Subject: 36 Carlton Avenue Aldwick PO21 3LR - AW/47/22/DOC

Planning Application Reference: AW/47/22/DOC

Proposal: Approval of details reserved by condition imposed under AW/130/18/OUT relating to condition 8-Construction Environmental Management Plan.

Condition 8 – Construction Environmental Management Plan (CEMP)

Construction Environmant Management Plan (CEMP) at 1 : 5 0 0 s c a l e

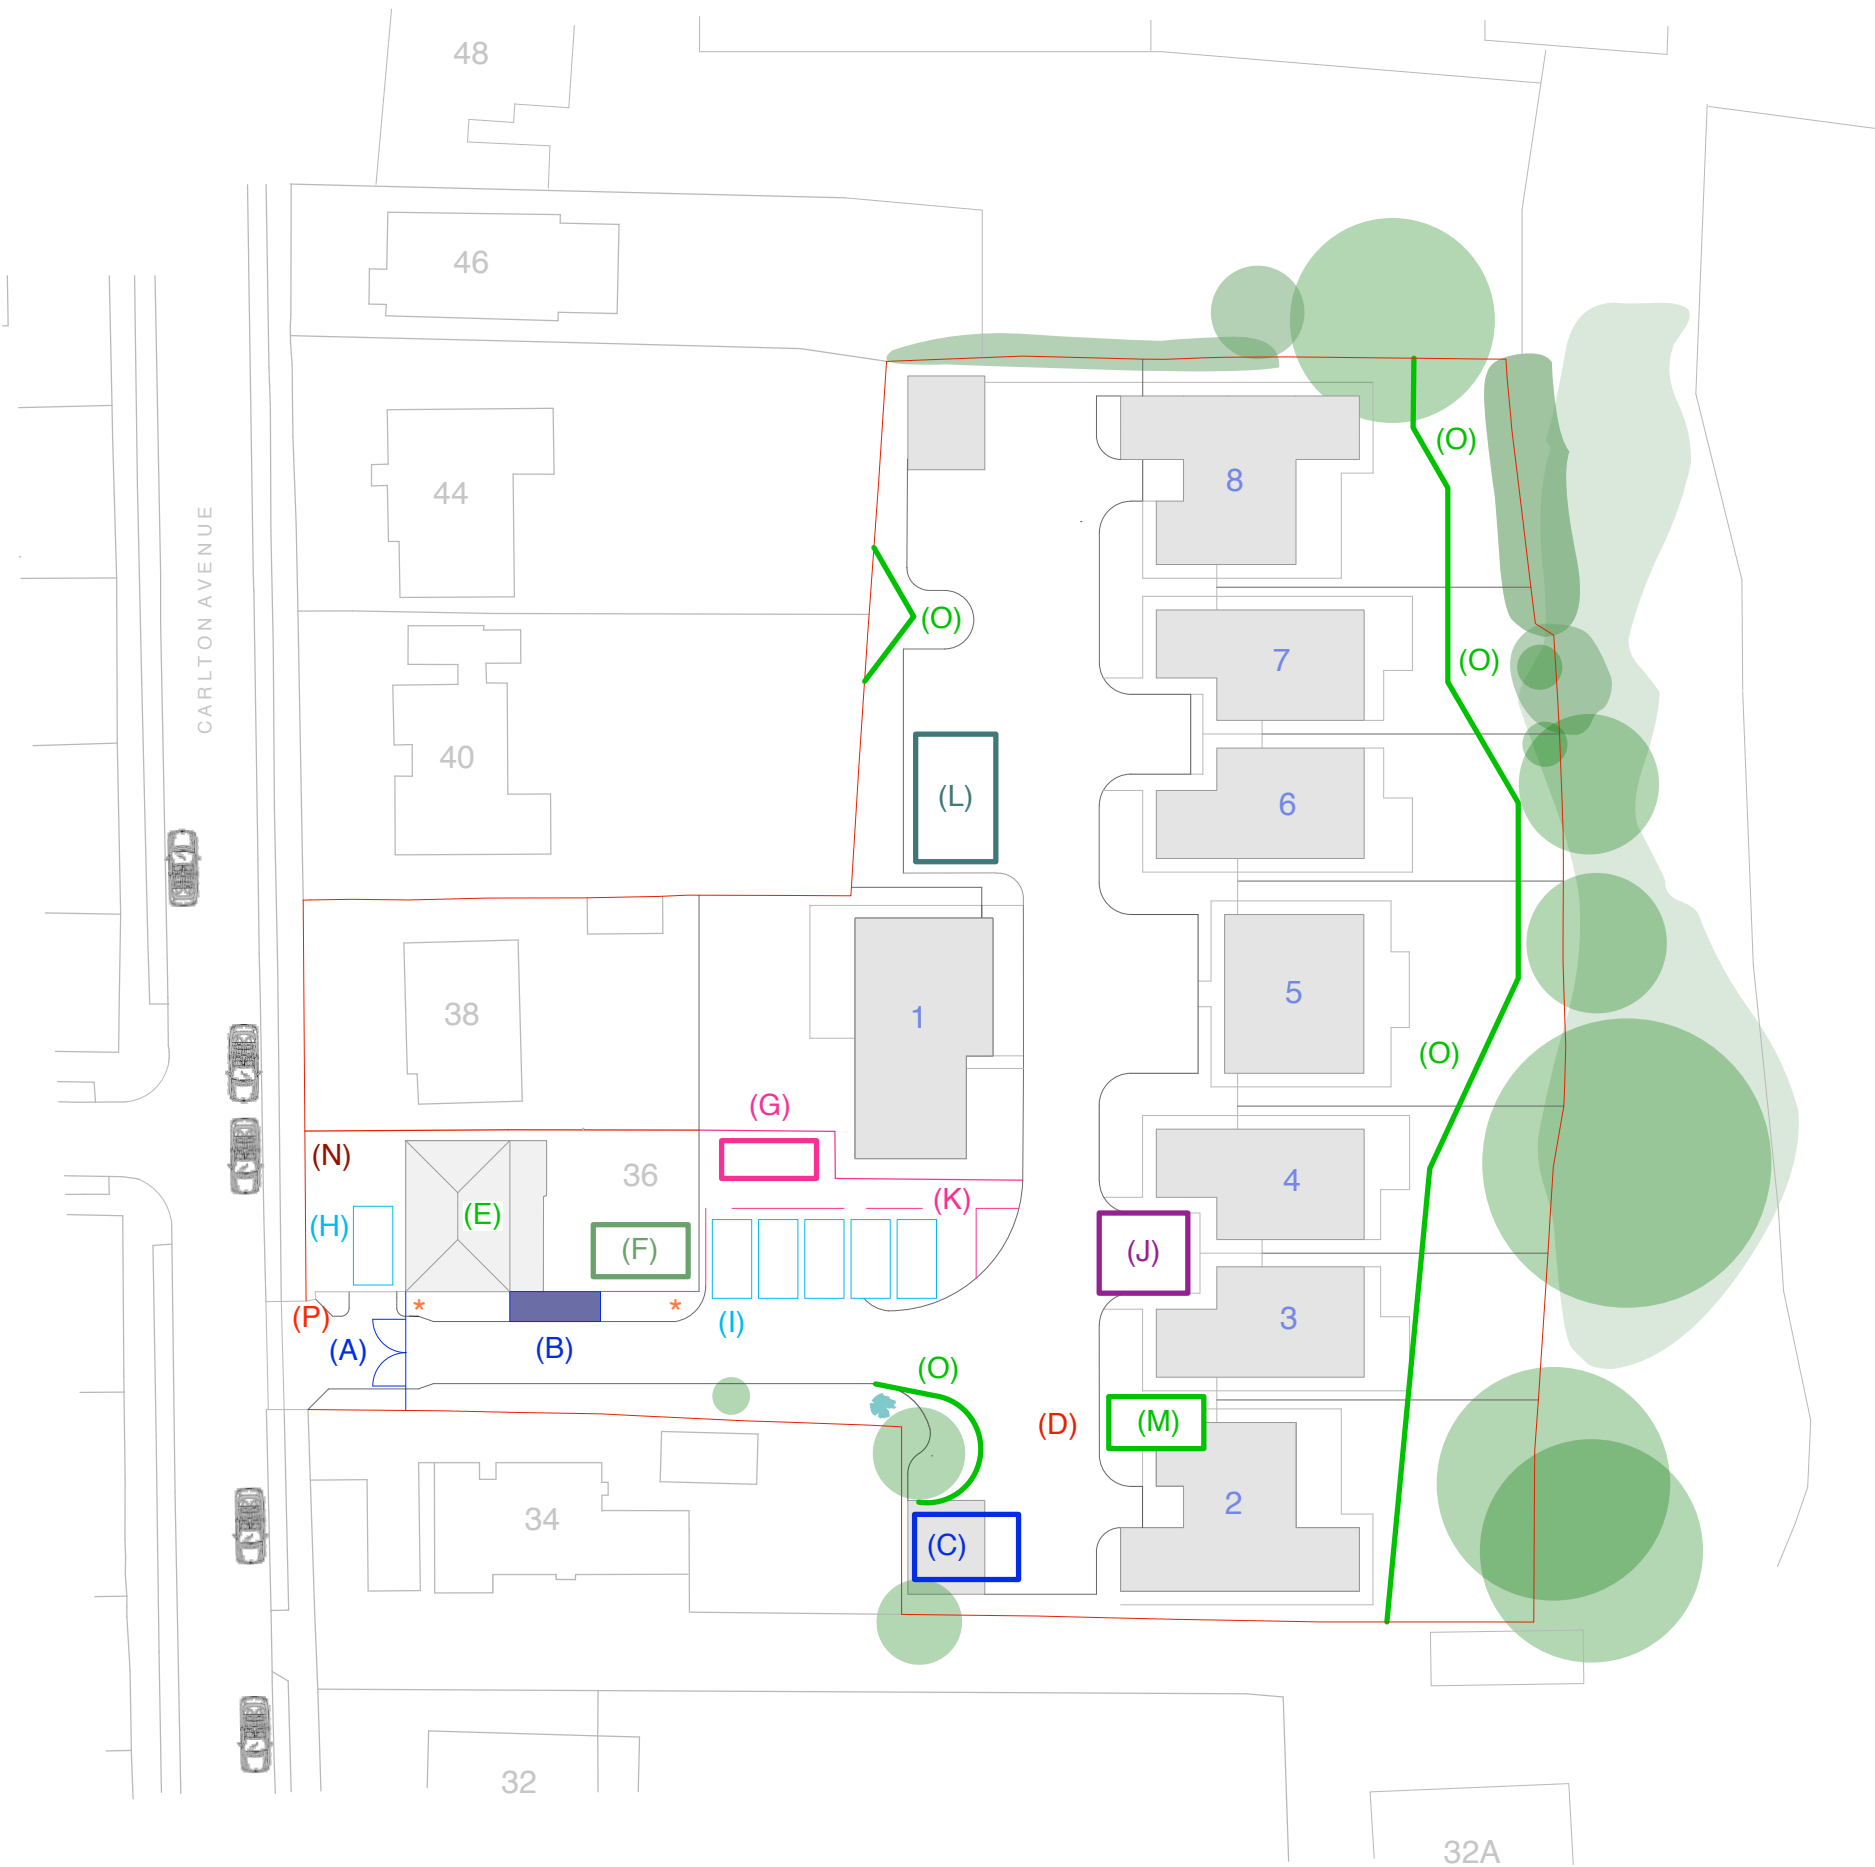
Having reviewed the document entitled 'Construction Environmental Management Plan' (dated no date) [produced by Counterpoint Properties Ltd.], I note the document is broadly compliant with the criteria detailed in the condition. However, the details pertaining to noise and dust control measures are lacking in detail.

I therefore request the applicant submit an amended CEMP to include that noise control measures shall be in accordance with BS 5228-1:2009 ; and submits further details regarding measures to control dust emissions on site. The dust control measures shall be in accordance with IAQM document 'Guidance on the assessment of dust from demolition and construction.'
